PLANNING CONSULTATION RESPONSE

Application No	2026/0387
Proposal	External alterations to existing workshop, storage and office building, including formation of first floor; installation of new windows; external materials; roller shutter door and associated works.
Address	Rear of 56 Hoyland Road, Hoyland Common, Barnsley, S74 0PB
Date of Consultation Reply	6 th August 2026
Consultee	Highways DC

DRAWING NUMBER:
HA-260301 - D4 - Proposed
Plans section and elevations
option 2

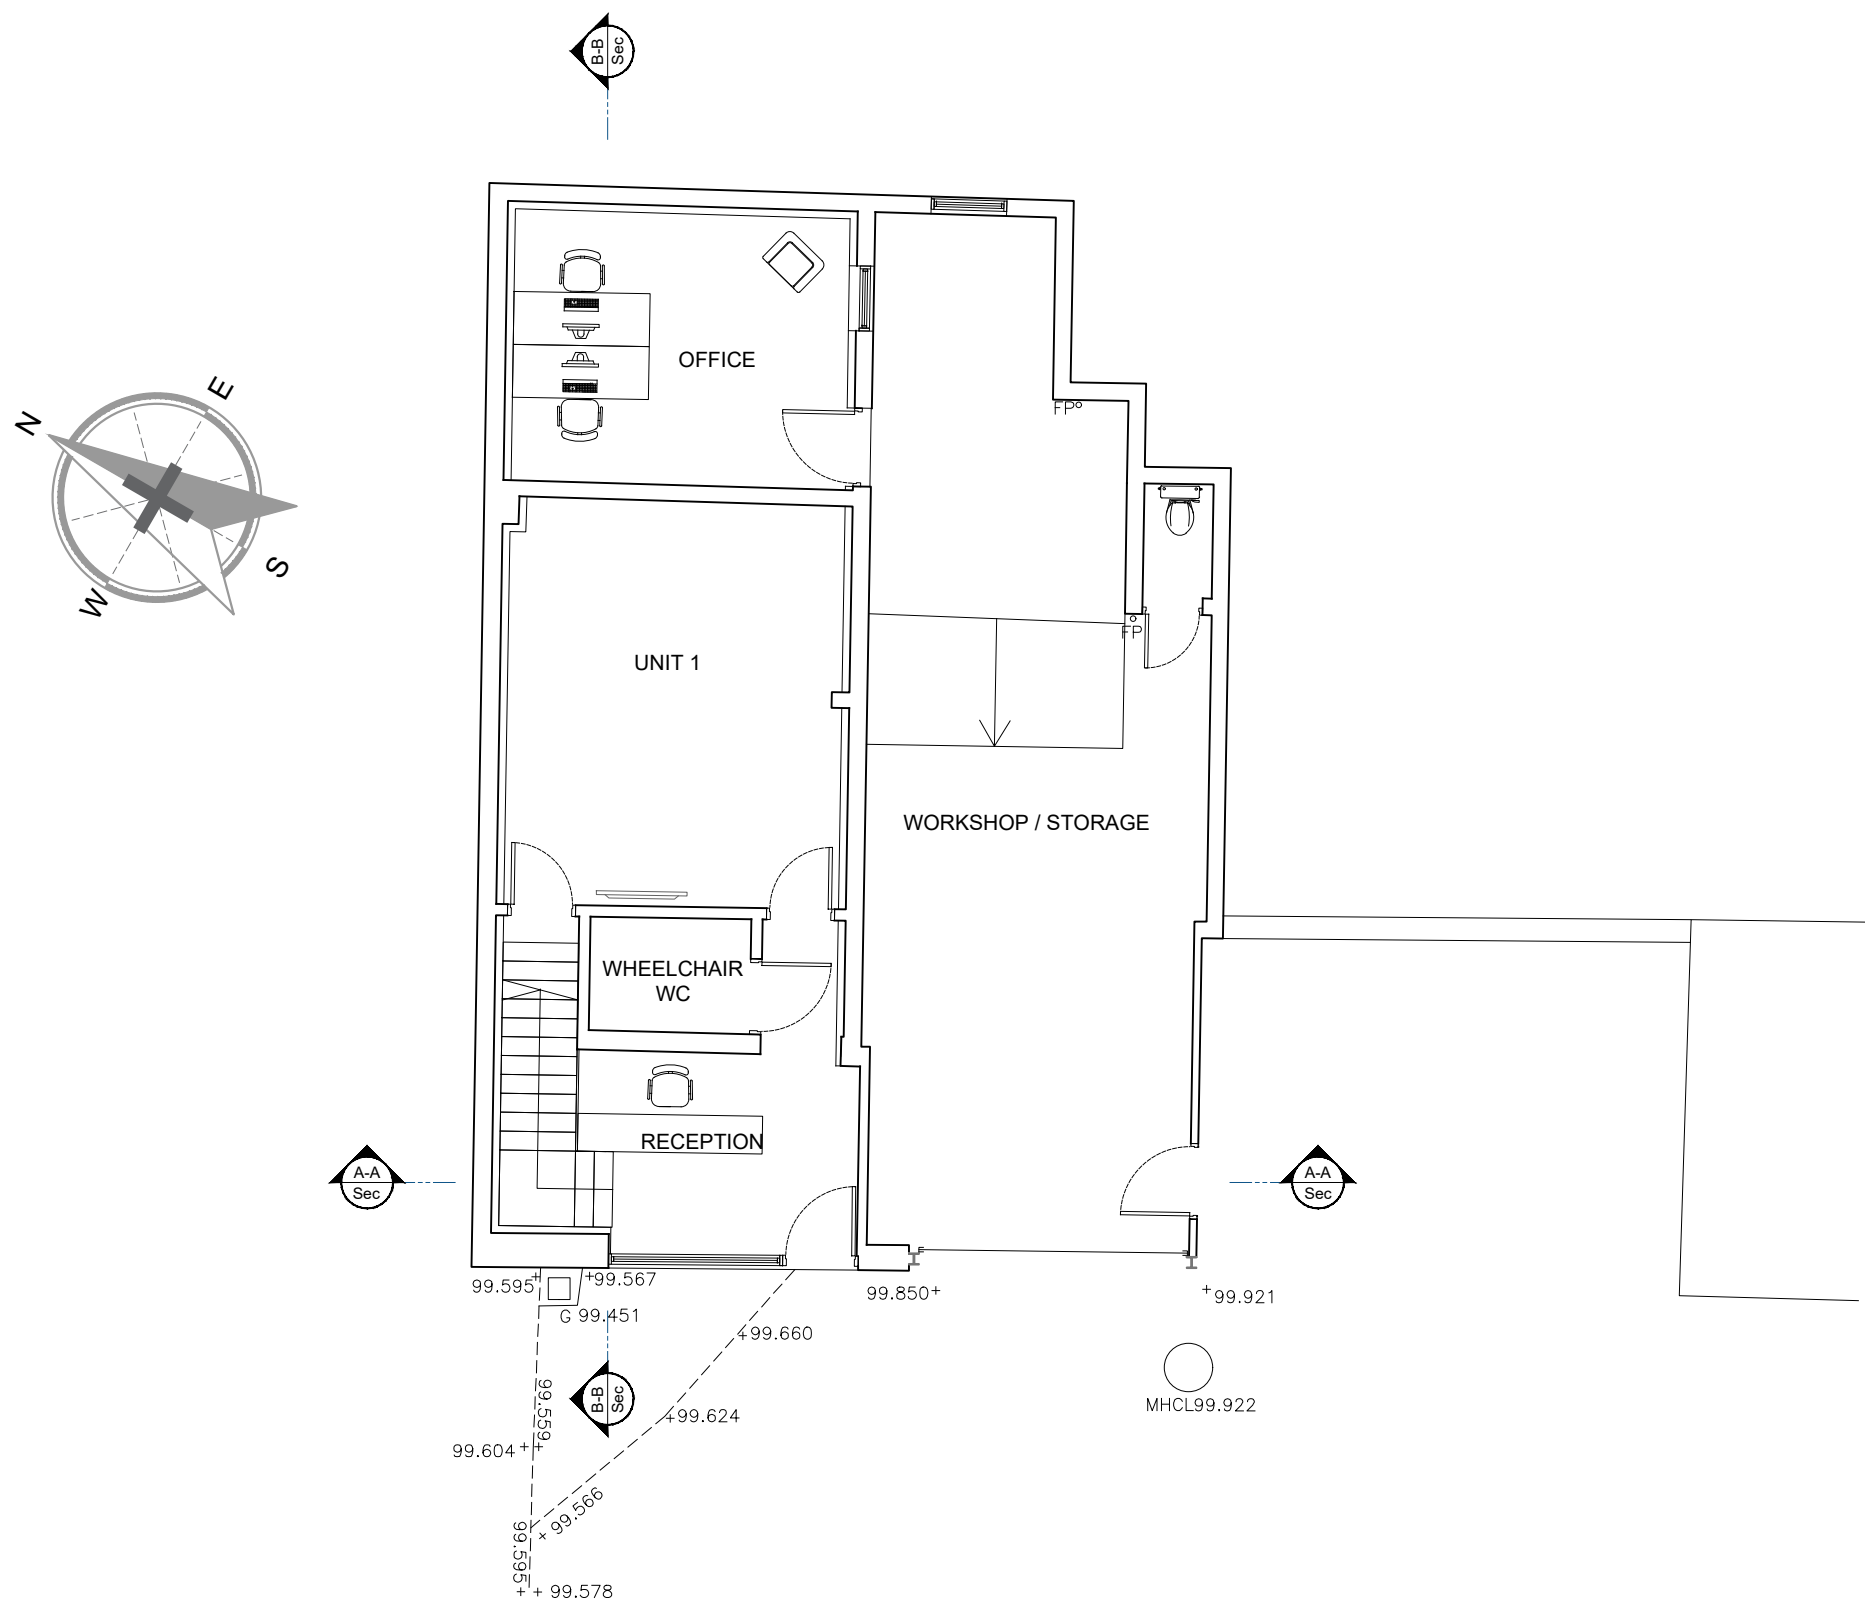
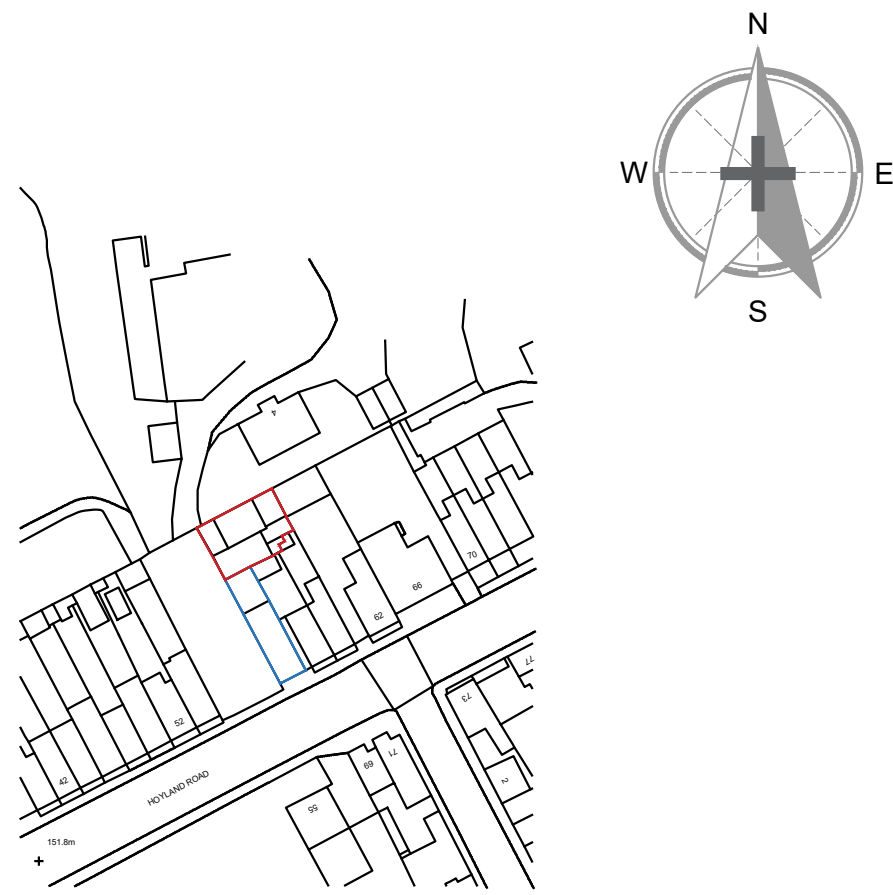
The proposals include a 37m² increase in floor area of Class E(g)(iii) use; this requires the provision of one additional off-street parking space. It can be seen from the supporting information that the site currently has one parking space and that no additional spaces are to be provided.

The submitted information indicates that the premises/business has no employees and that none are proposed; as such, further details should be provided with regard to the intended operation of the site including the total number of people that could be at the site at any given time along with the anticipated number of vehicular movements during a typical day. These details should include the proposed parking locations of any vehicles associated with the premises.
